Engineers Comments Regarding Surface Water Drainage

Application Reference:	BE/15/26/PL	Reviewer Reference:	ADC/EXT3/RW
Planning Officer:	Simon Davis	Date of Review:	22/06/2026
Site Name:	Land East of Heath Place Bersted PO22 9SL		
Application Description:	Erection of a 3-storey building comprising of under-croft car parking and bicycle store, 2 floors of 4 No self-contained flats on each (8 No flats in total) with pedestrian access formed onto Ash Grove. This application is in CIL Zone 4 (Zero Rated) as flats.		
Assessment Number:	1

PROPOSED Lower Ground Floor Plan

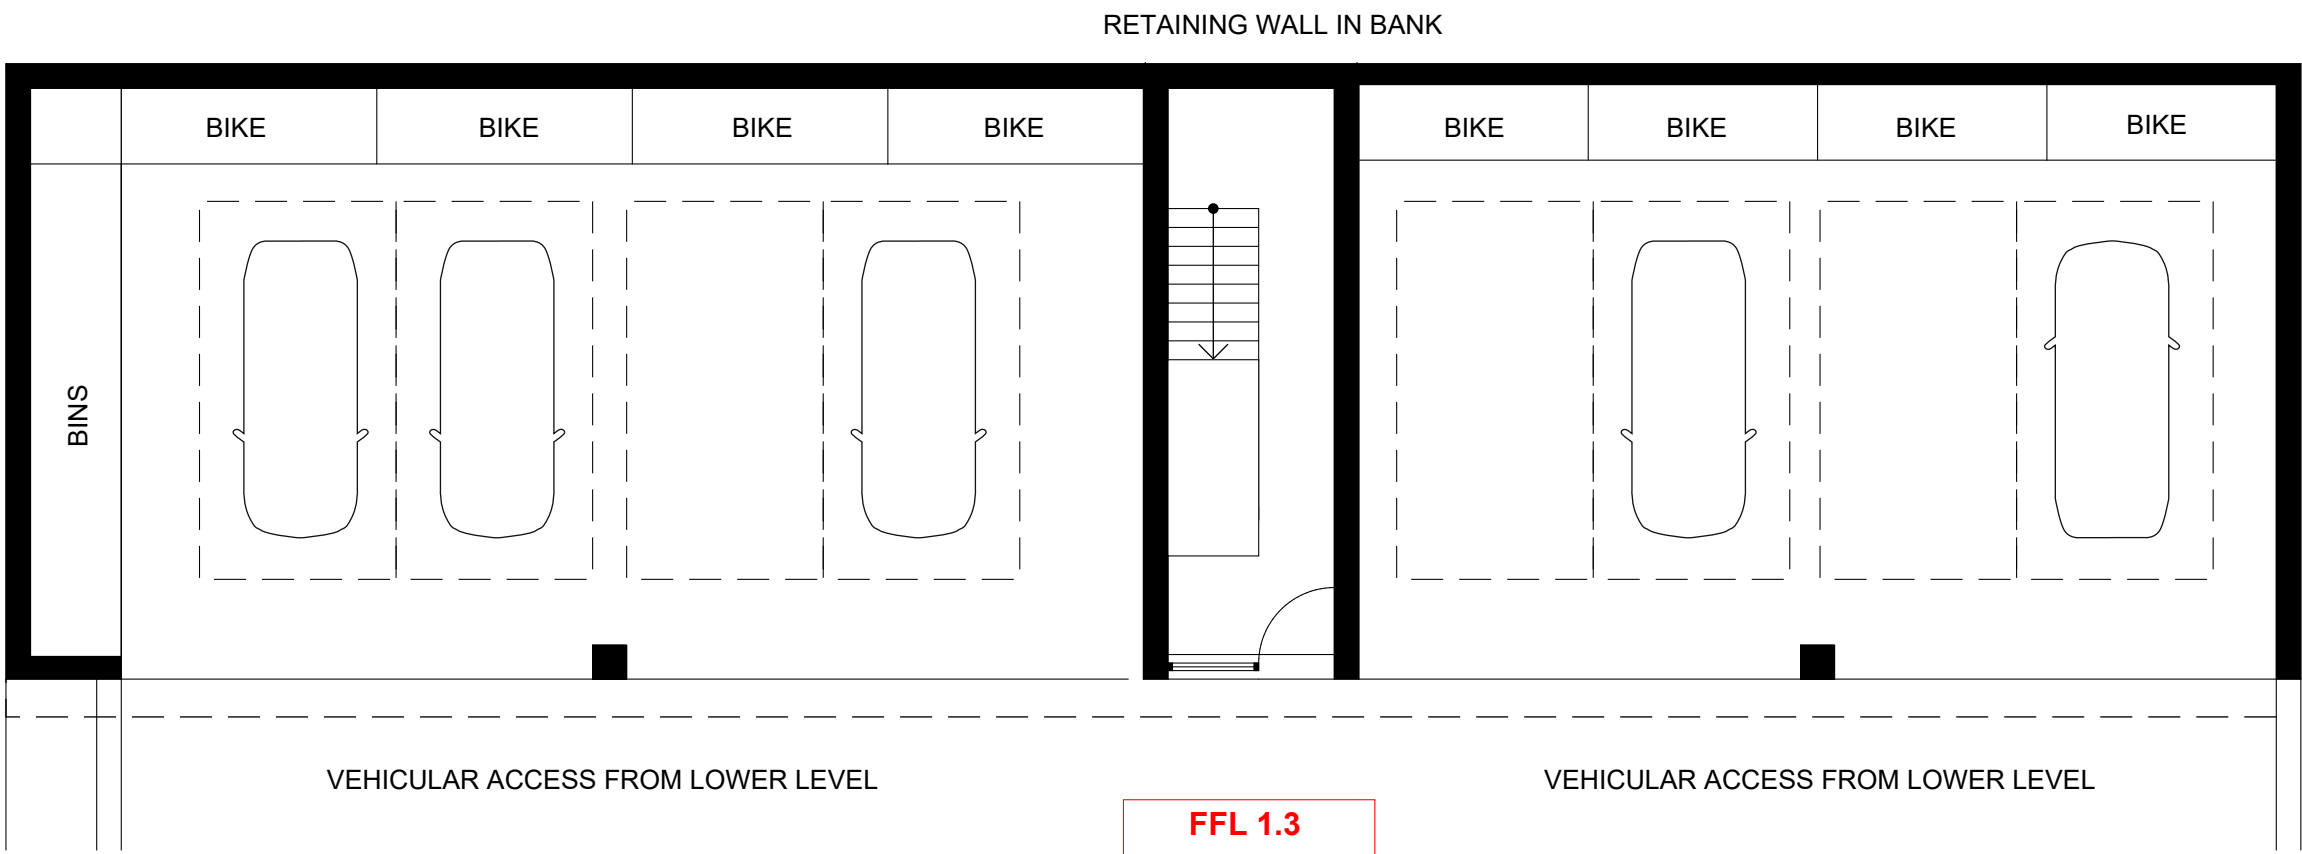
- 3.1. Top of tank level is noted as 1.95m AOD on the drainage plan within the updated flood risk assessment. The proposed level of the undercroft car park is noted as 1.3m AOD, clarification required on how the system will not back up and flood the undercroft area.
- 3.2. Should pumping be proposed it would only be accepted in exceptional circumstances when all other options have been fully considered The National SuDS guidance notes:
The use of pumping within surface water drainage systems shall be by exception only and agreed with the approving body due to the associated carbon, energy and maintenance implications, and the risks associated with failure and exceedance.

- 3.3. The undercroft car park sits lower than the cover level for the outfall manhole, can the engineer validate that the property will not be at risk of flooding in the event of surcharge to the sewer under Ash Grove.
